# Add: PCD File No. PPR2432

# V-1 Legal Description Redlines.pdf Markup Summary

EXHIBIT F
RECLAMATION PLAN MAP - SOLBERG PIT
 SECTION 21, TOWNSHIP 13 SOUTH, RANGE 64 WEST
 OF THE 6TH P.M.
 EL PASO COUNTY, COLORADO

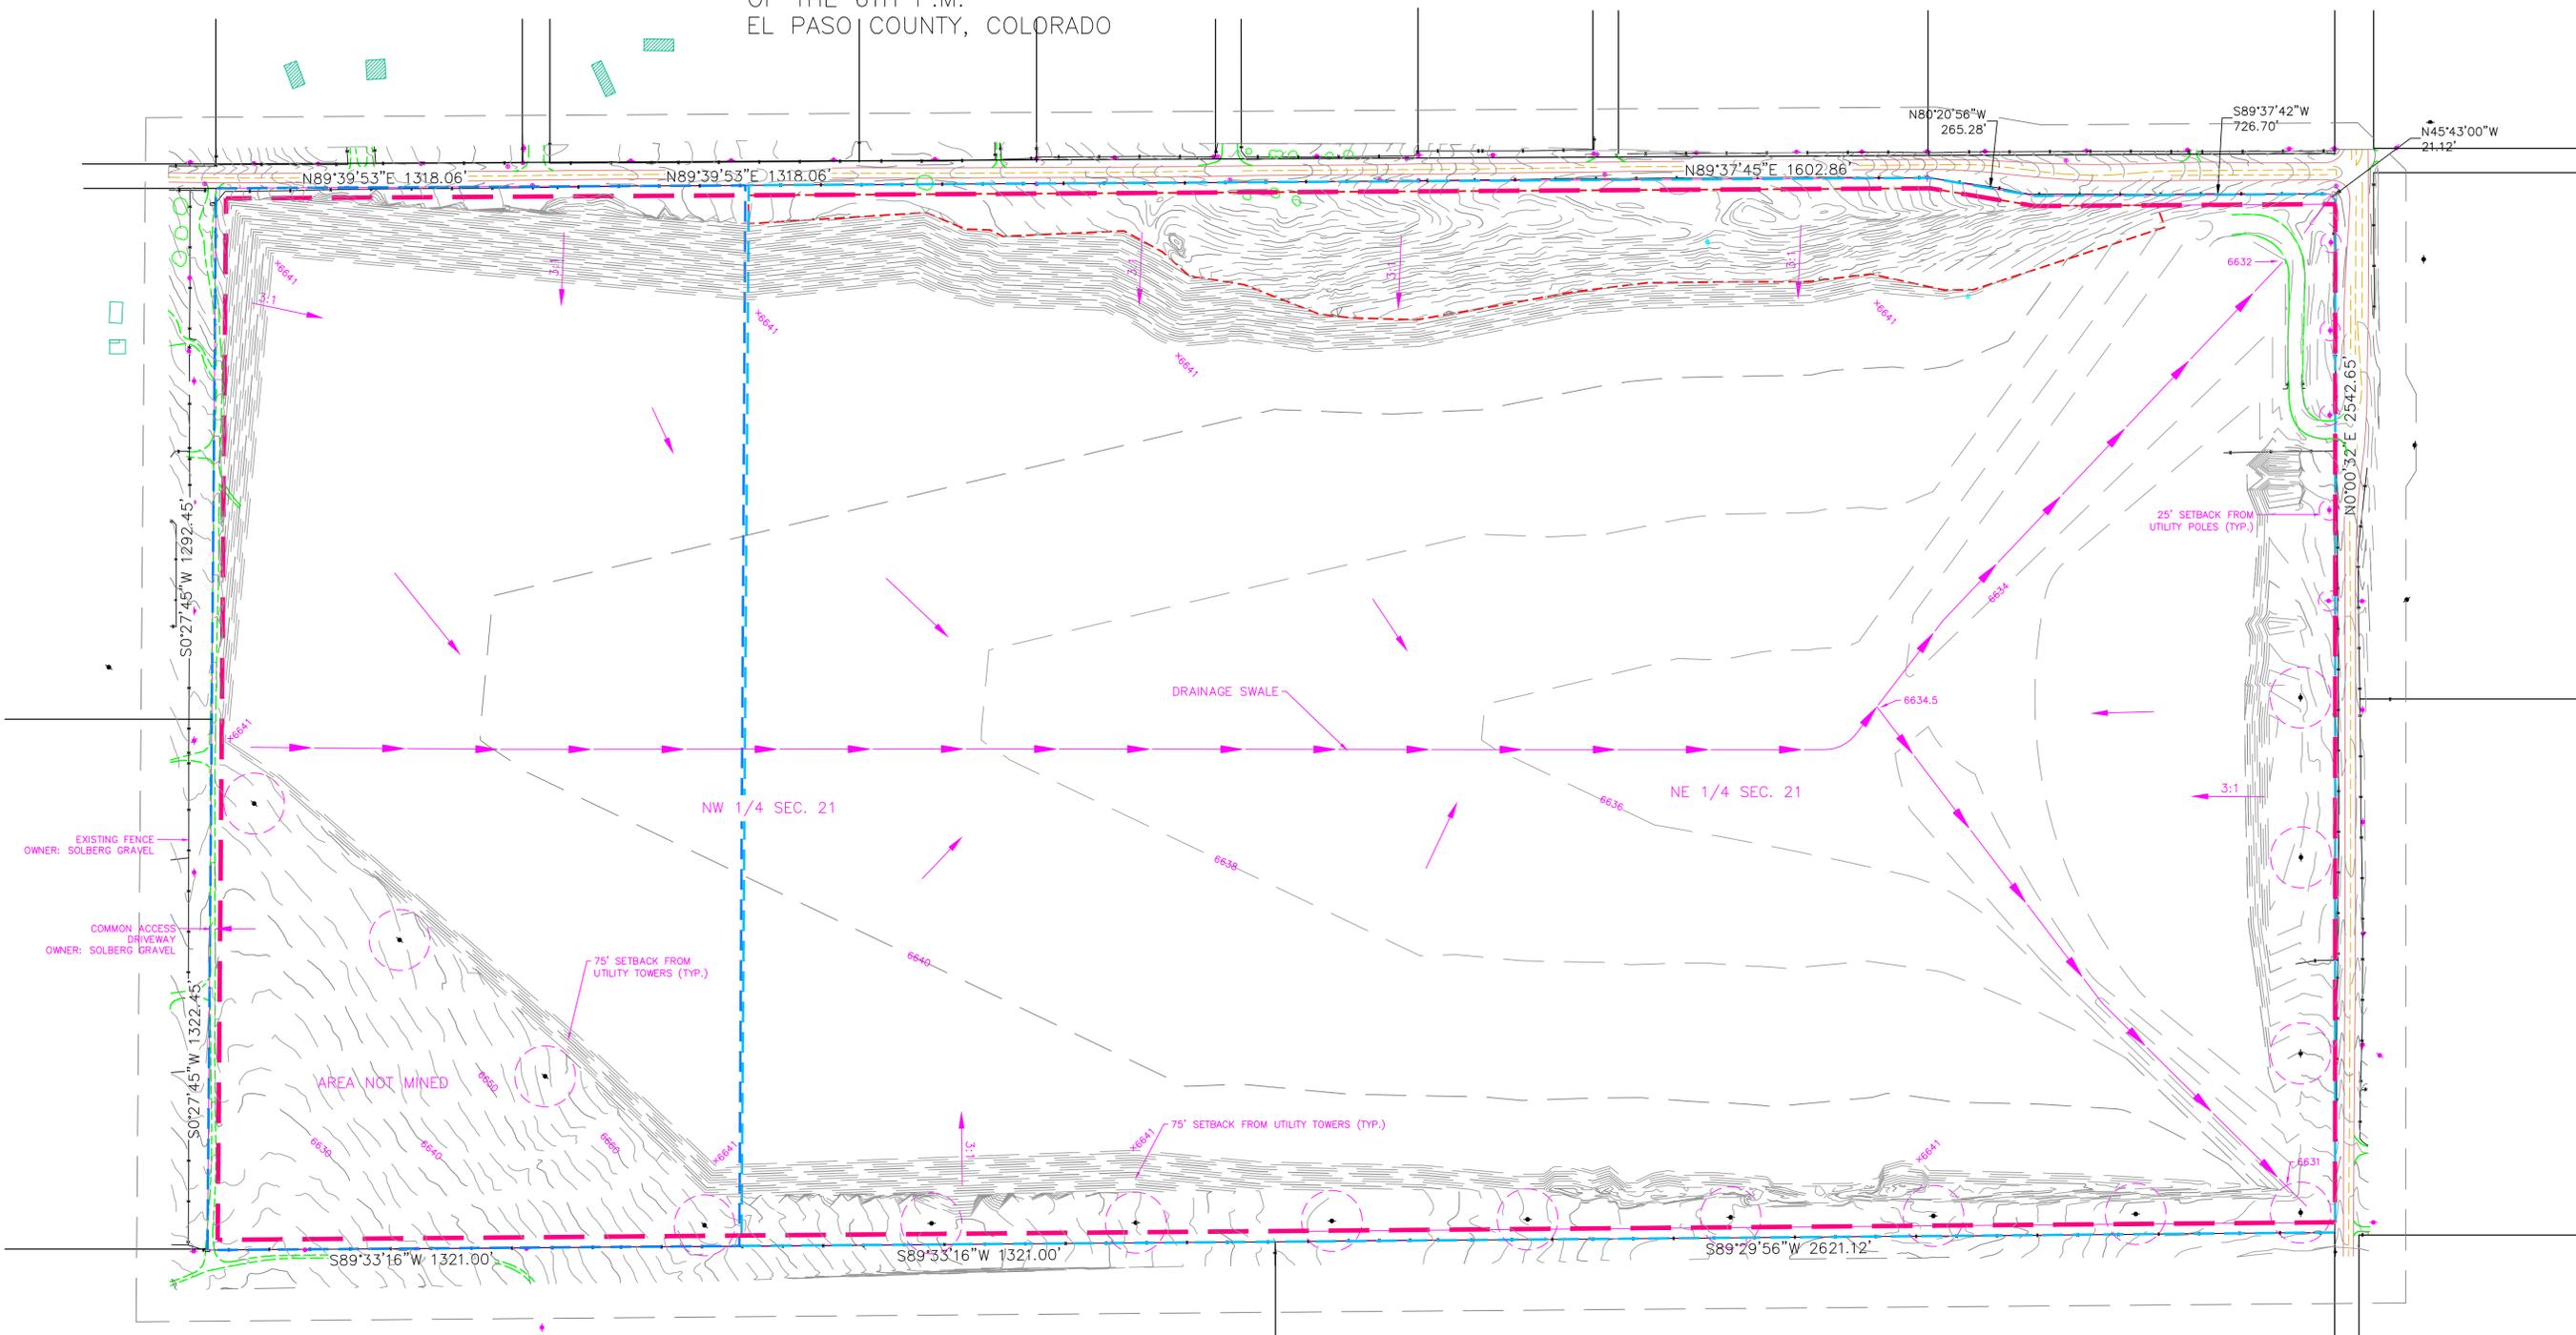
Add: PCD File No. PPR2432
